LEE GAMELSKY ARCHITECTS P.C.

RE: Albuquerque School of Excellence – Remodel
13201 Lomas Blvd NE, Albuquerque, NM 87112

Building Permit NO. 201691547

Final Certificate of Occupancy: Traffic Circulation Layout

B1 TRAFFIC CIRCULATION LAYOUT PLAN
1" = 40'-0"

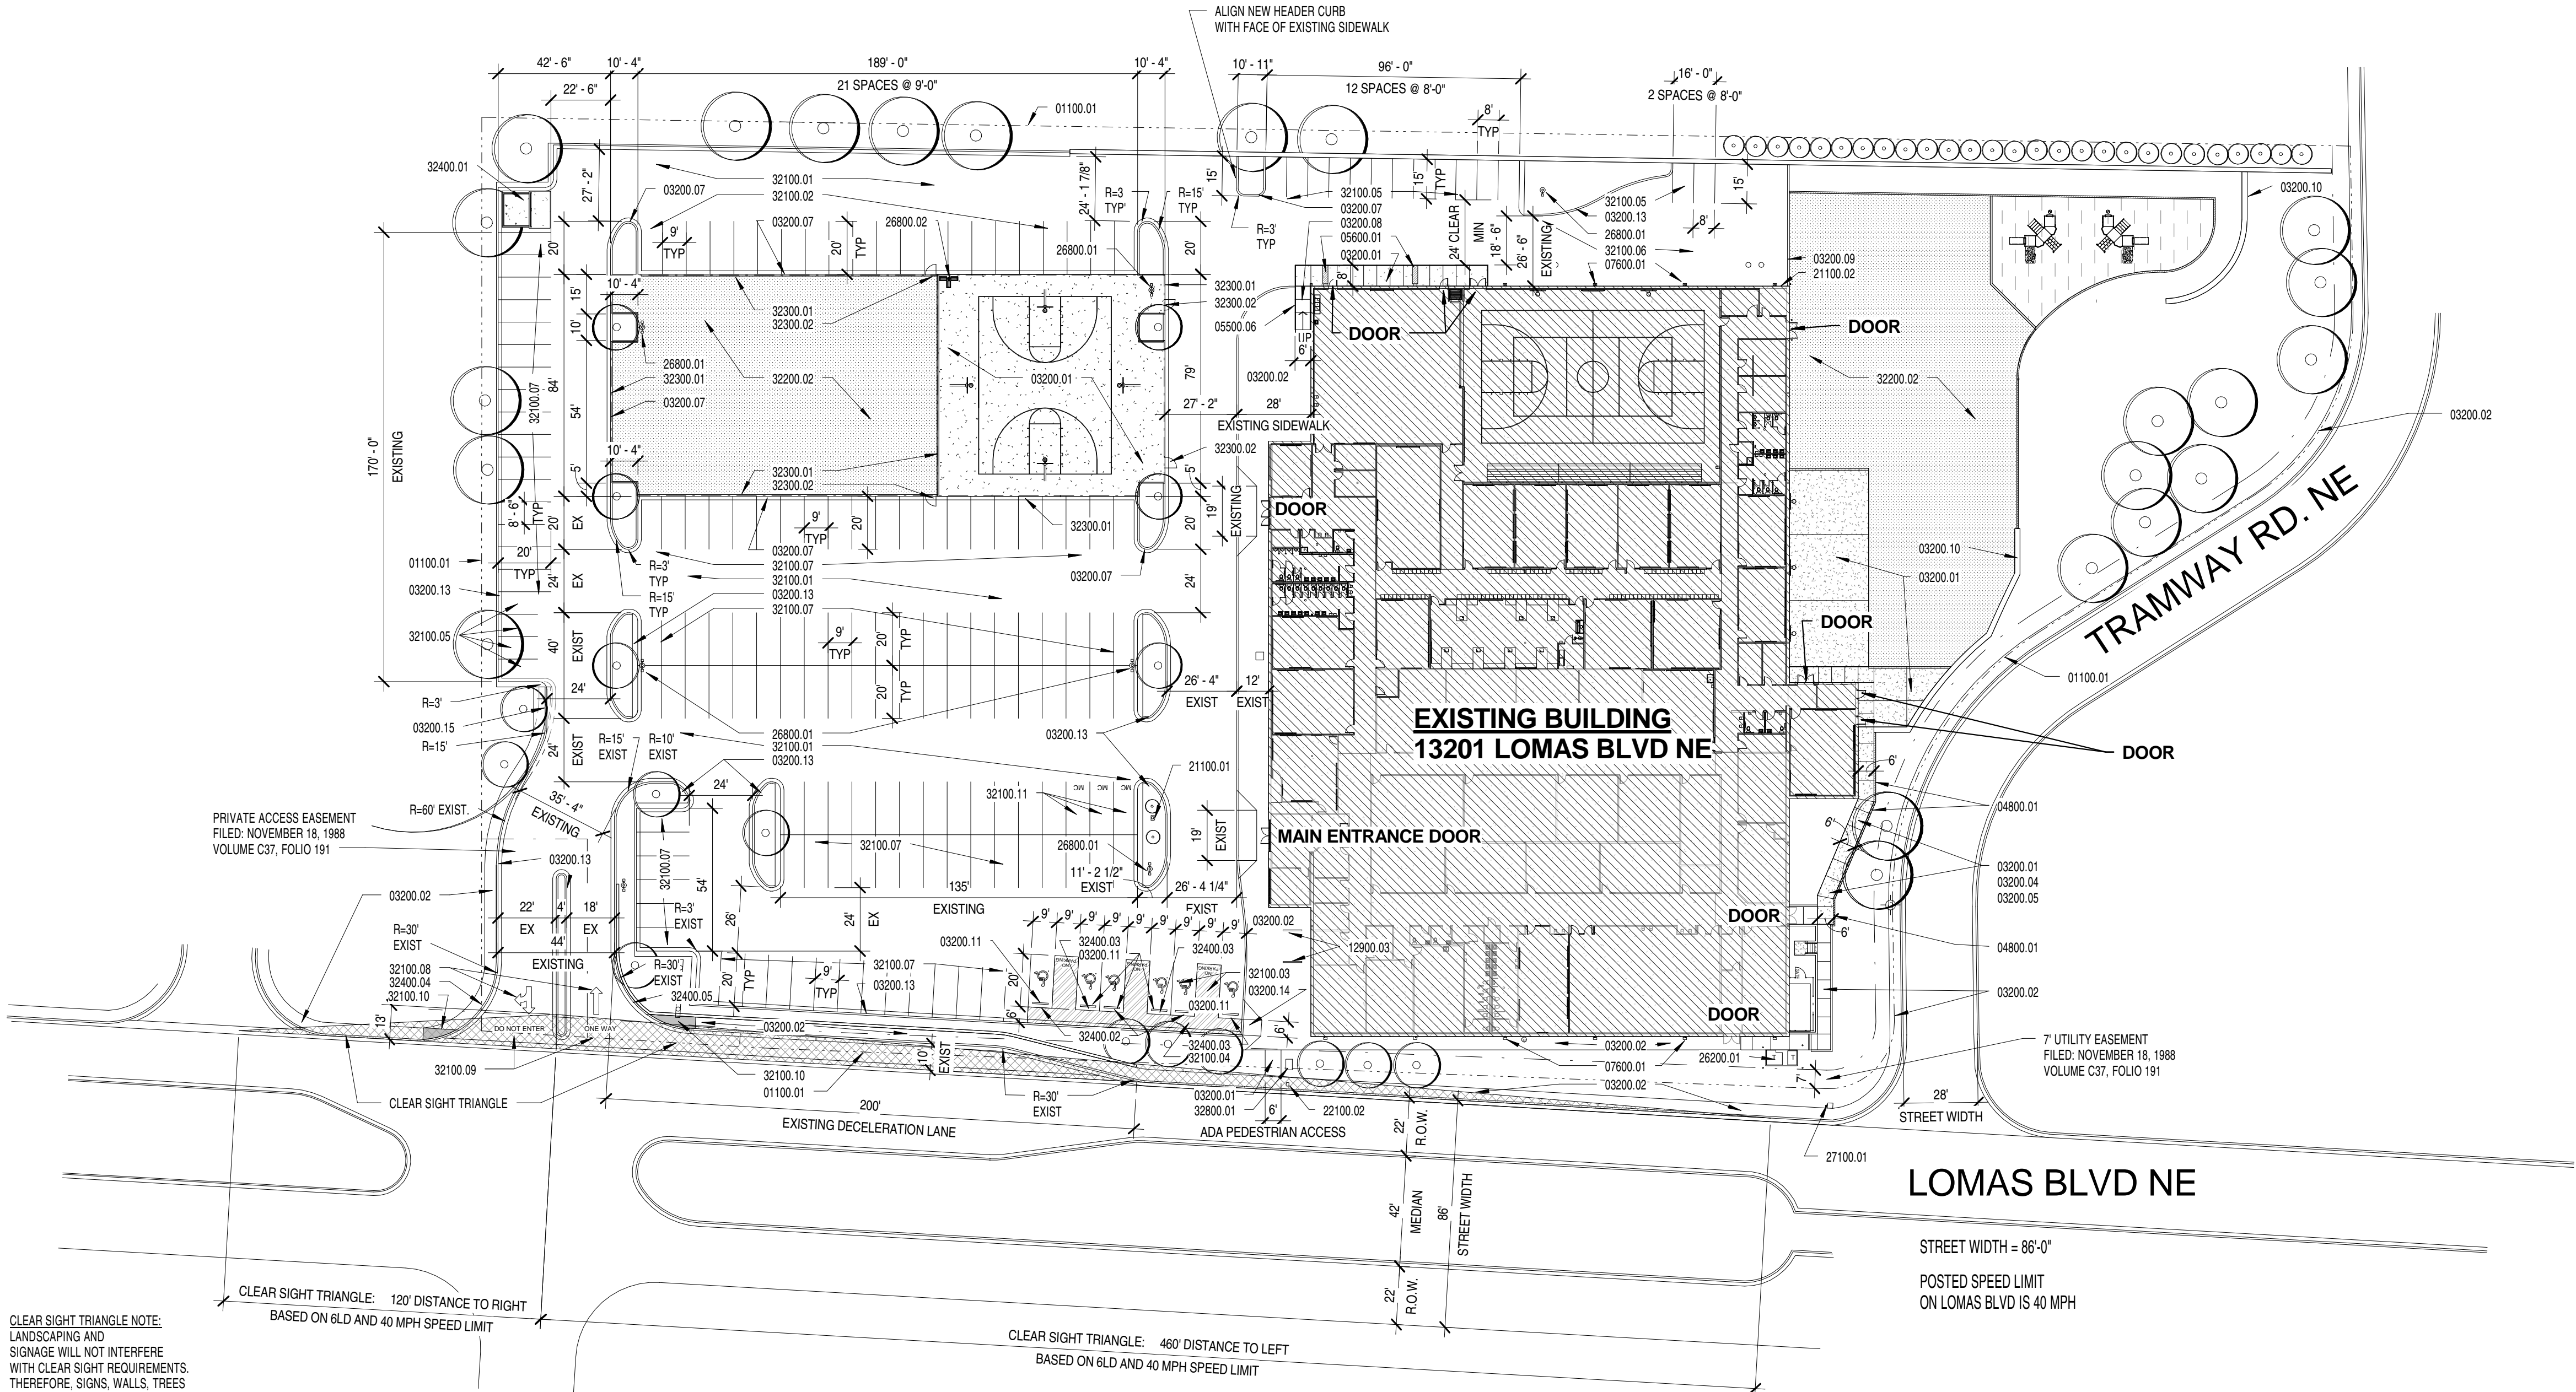
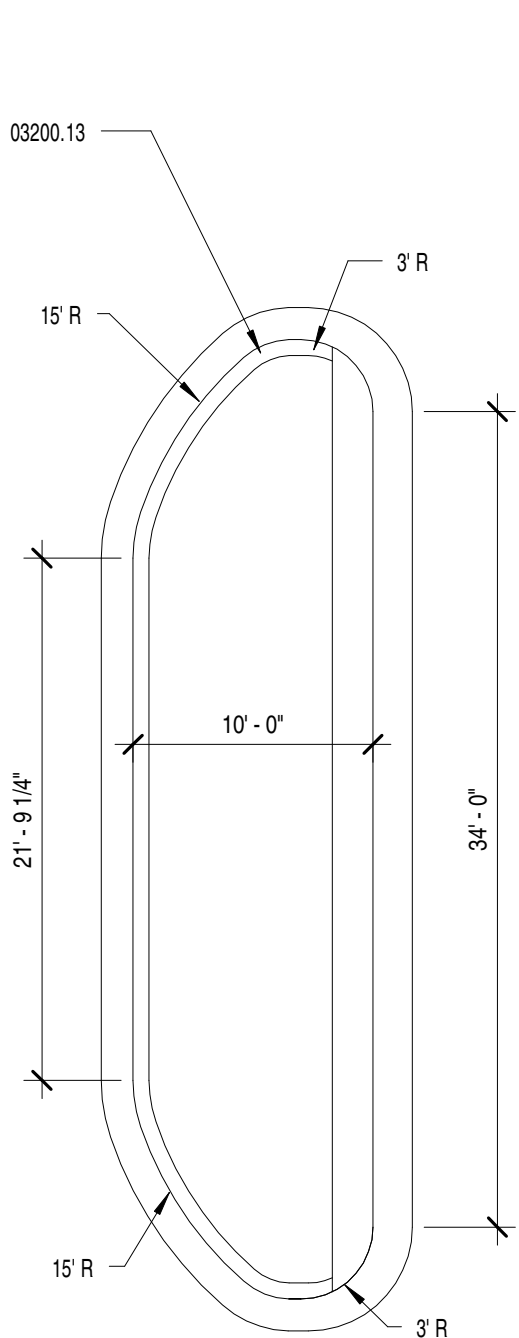
The Owner of the project referenced above has decided to not perform some of the Site Improvements on the project as described and illustrated in the Drawings and TCL. The playground/recreation areas on the west side of the building (within the parking lot) and on the east side of the building will not be constructed at this time. The asphalt areas will remain as is.

These items were redlined in the City and General Contractor's Permit Sets.

Therefore, as suggested by Monica Ortiz, we would like to withdraw the TCL from the Permit Set and not have that work as a condition of approval for a Final Certificate of Occupancy.
